1 Joy Place (CBL #045 E049; ID#2017-128) comments

This email outlines some concerns around the plan for the building being constructed at 1 Joy Place (CBL #045 E049; ID#2017-128).

NO.	DATE	REVISIONS
1	4/25/2017	SUBMITTED TO CITY OF PORTLAND FOR REVIEW
2		
3		
4		
5

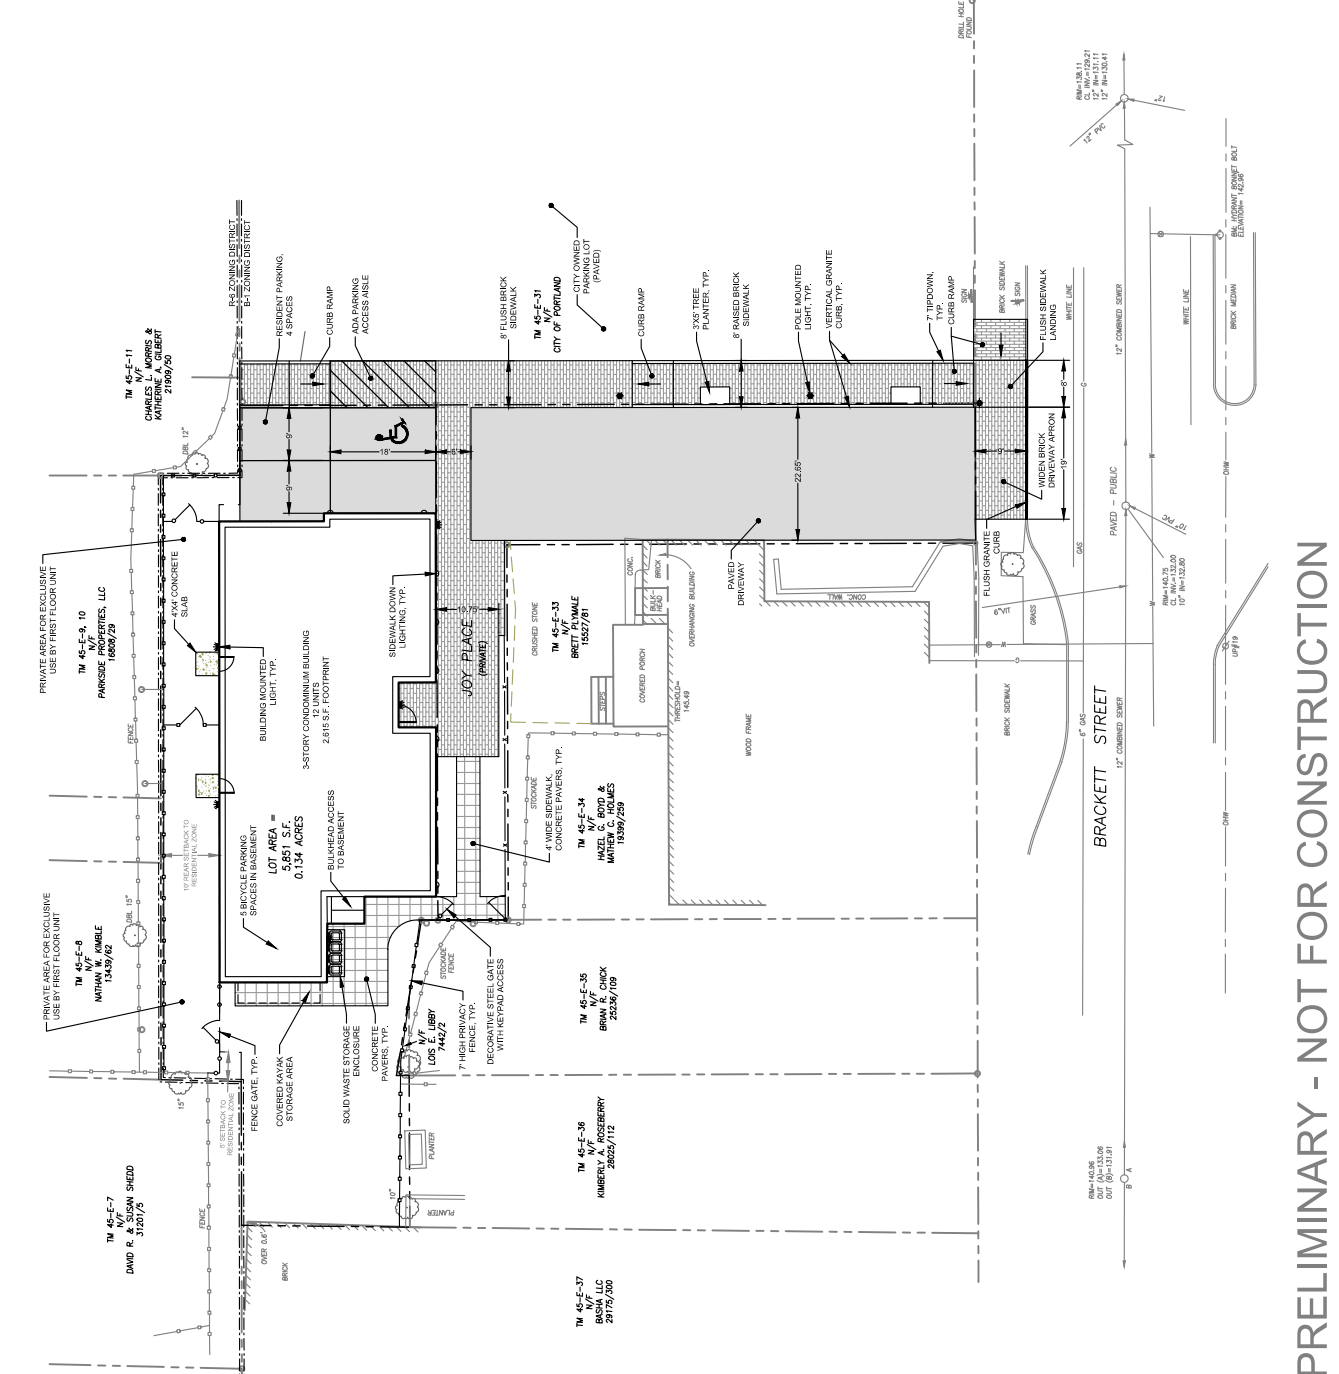
Looking at the submitted plan, it is not clear that the passageway remains sufficiently open. There wasn't a scale on the landscaping plan, so I couldn't measure it to confirm the width. I know it is tight with 1 Joy Place structure being built right up to the edge of right of way.

I also could not tell if the low-growing vinca is actually growing in a raised bed that would impinge on the travel lane.

We ask that the paving and landscaping keep the right of way a clear 12' wide, allowing for vehicles, without running into/over planting beds.

- Use a fence on our property line that is **7' or taller** and that has **no gaps between fence boards** (to maintain visual privacy between the passage between our buildings and our back yard).
- Use **solid material (wood) for fence gate** material, also for privacy.
- **Relocate gate 3-6 feet from the corner where it is located** on the plan (existing plantings on our property are in the way if it stays the corner location and would obstruct passage)
- Confirm that our deeded right of way is a clear **12' wide** and allows for vehicle passage.
